Our Reference:
SWS-SUSXW-S106-010711

Date:
20/10/2017

Application to Connect to the Public Sewerage System - Section 106 Water Industry Act 1991. Location: 20 Sea Drive, Felpham, Bognor Regis, West Sussex, PO22 7NE.

Section 106 connection into existing storm manhole (adopted)
Scale 1:20

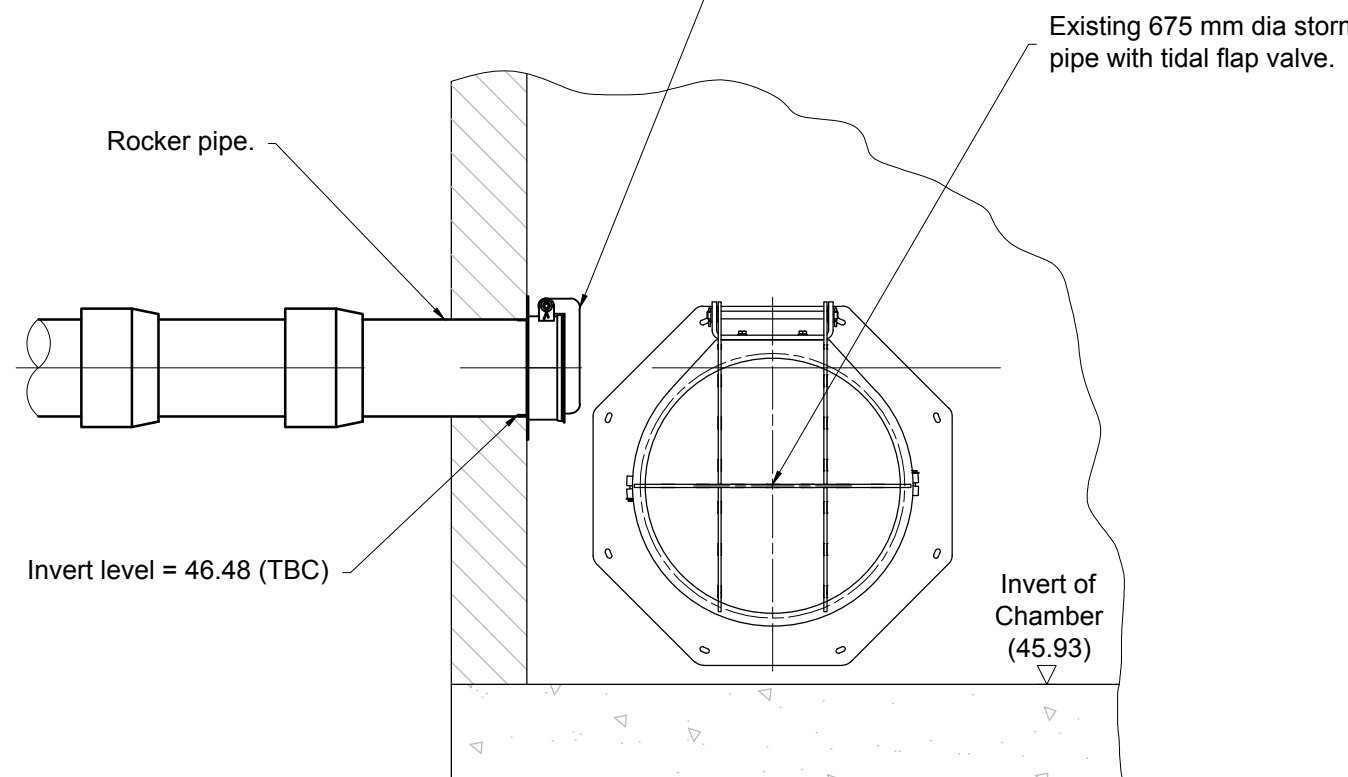
Further to your recent application to connect to the public sewerage system at the above location, I am pleased to inform you that your proposal to connect to the surface water sewers via an existing manhole has been approved subject to the following provision: -

Connections to existing manholes and arrangement of pipe junctions within the manhole should be in accordance with Sewers for Adoption 7th edition and Southern Water guidance documentation.

- The angle of the connecting pipe work at the point of entry through the manhole wall shall not be less than 90-degrees relative to the direction of flow in the main sewer at the point of exit from the manhole.
